REF: 21/03150/REM

Location: Begbroke Science Park Begbroke Hill Begbroke
OX5 1PF

19 October 2021

Building A - Academic Building

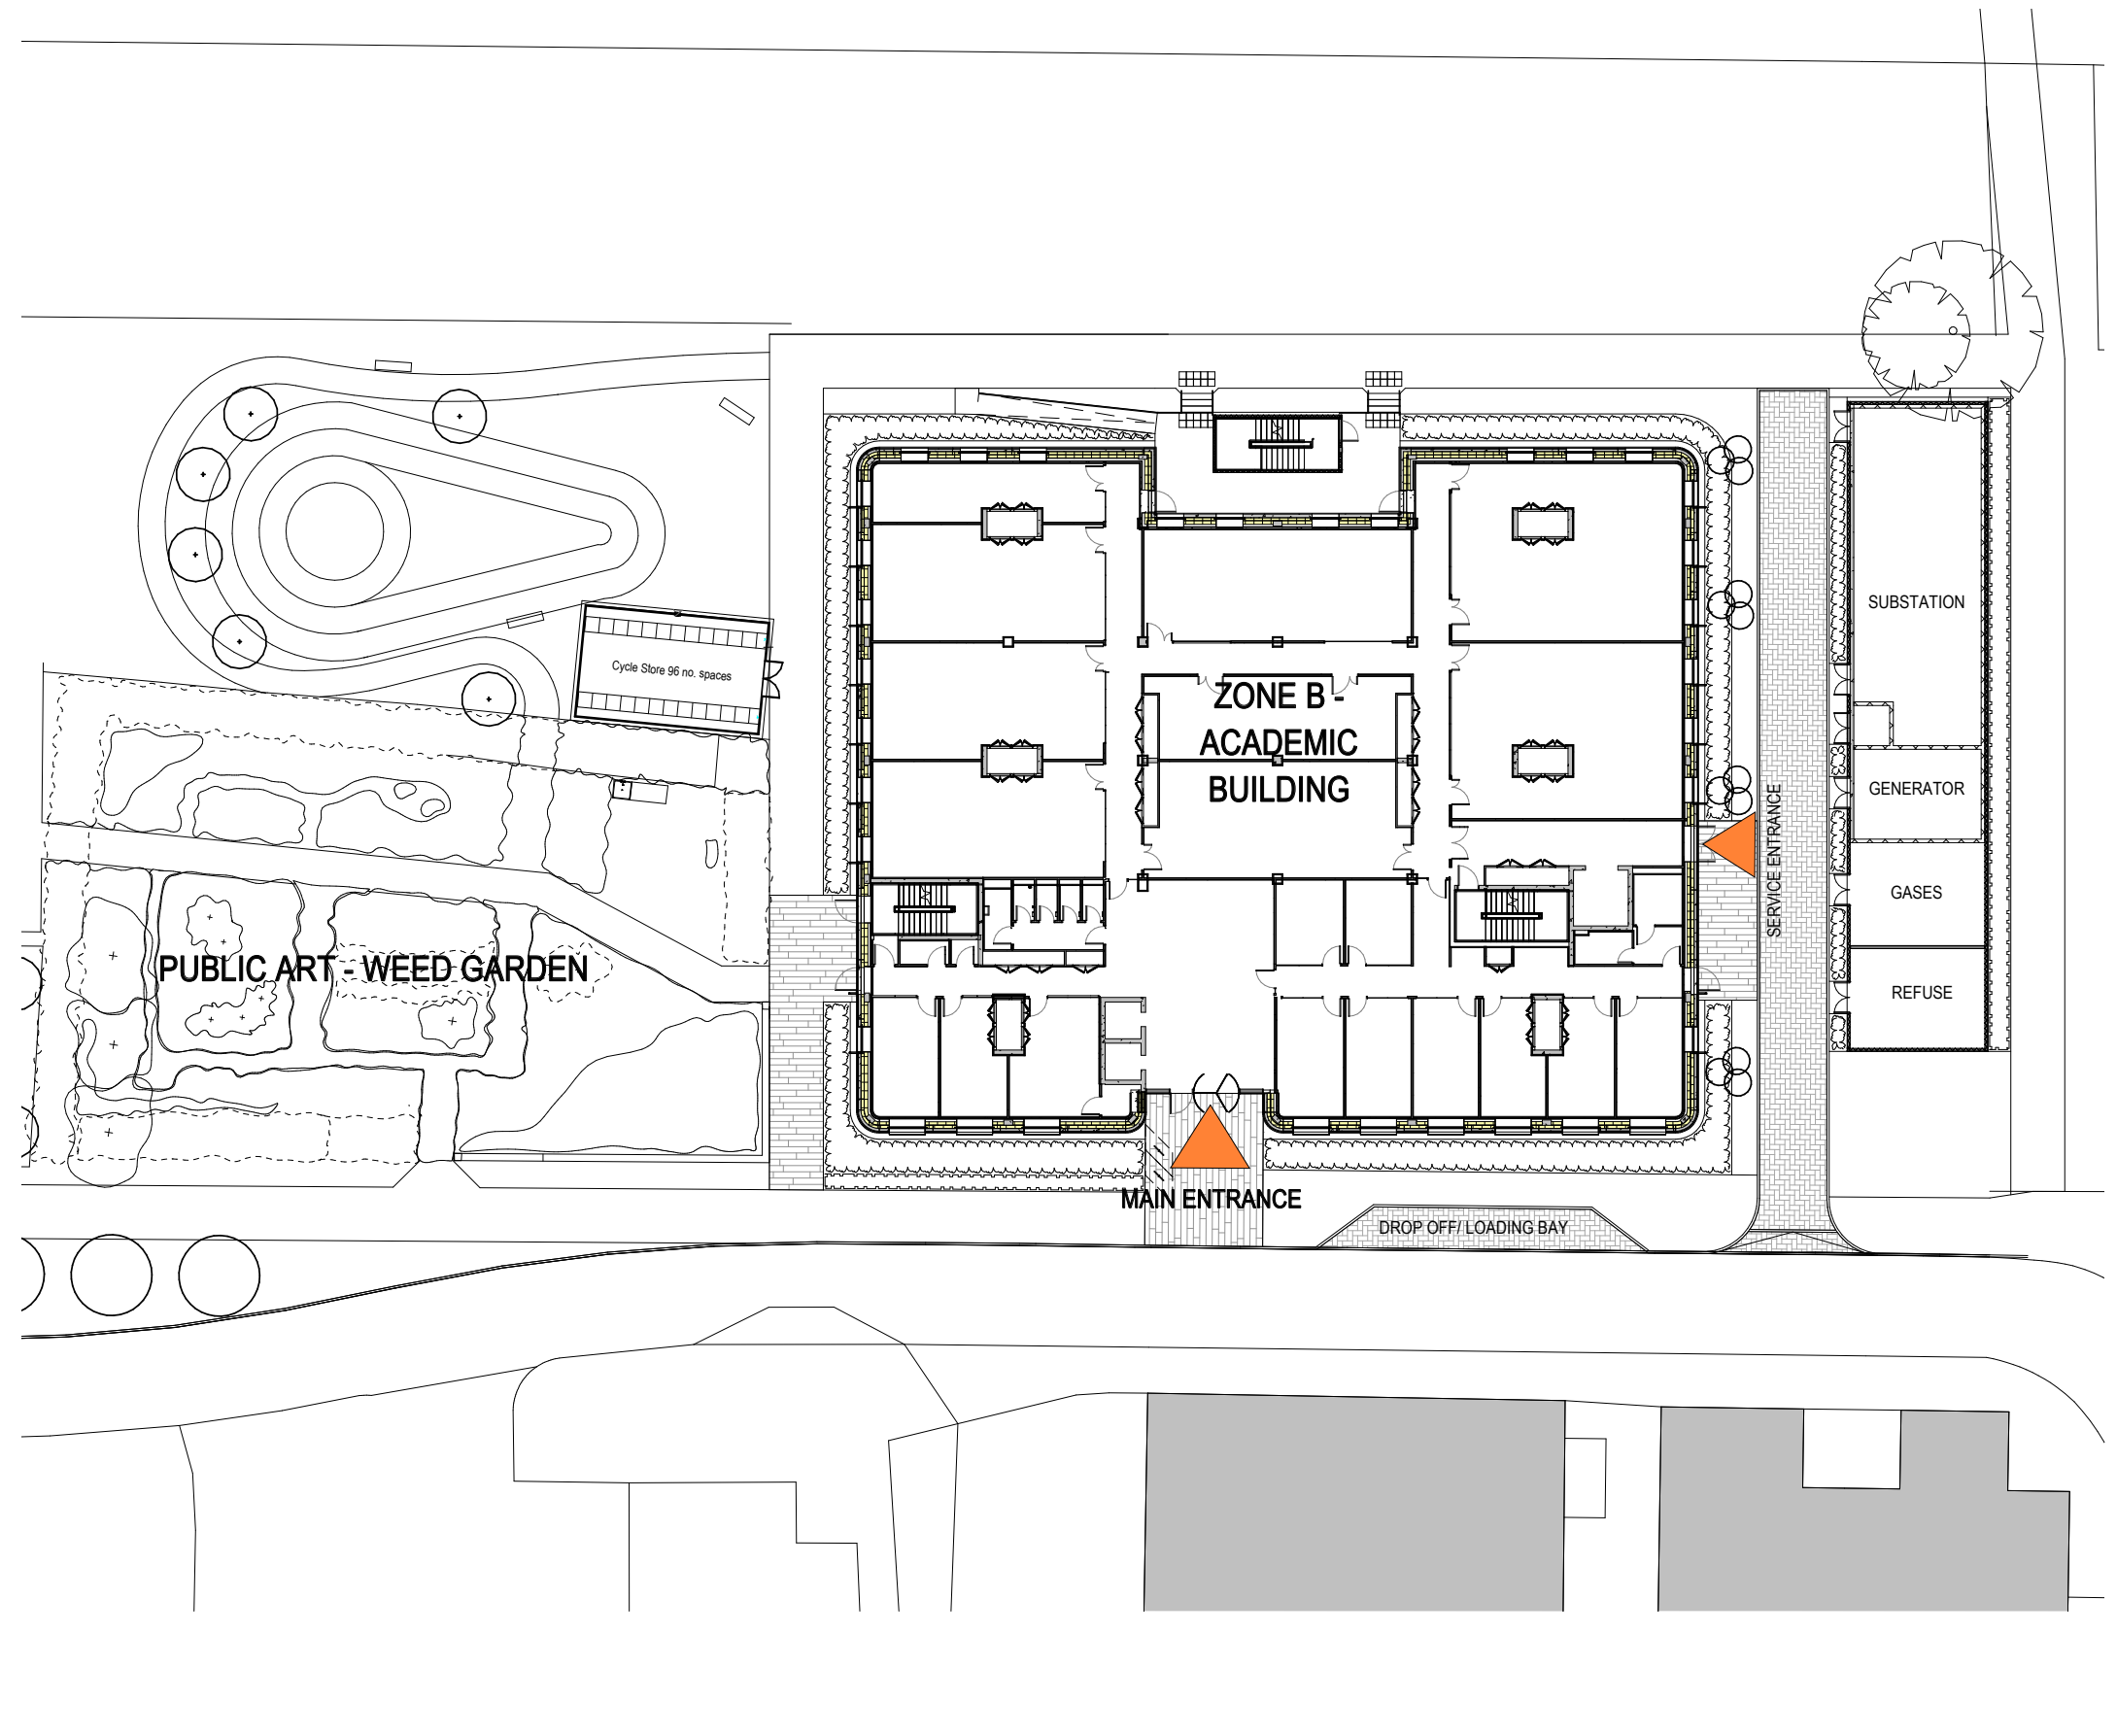
I have concerns that the cycle storage for the academic building is located in an area with little natural surveillance, also screened from view by a large established hedge. This leaves the store vulnerable to crime and antisocial behaviour. Cycle crime is one of the biggest demands on policing within Oxford, and in order to address my concerns I ask that the store is located to a more appropriate location where it will be covered by sufficient natural surveillance. Having reviewed the site, I believe the cycle store would be far better located to the south of the proposed ancillary building, next to the bin store which is much better suited location:
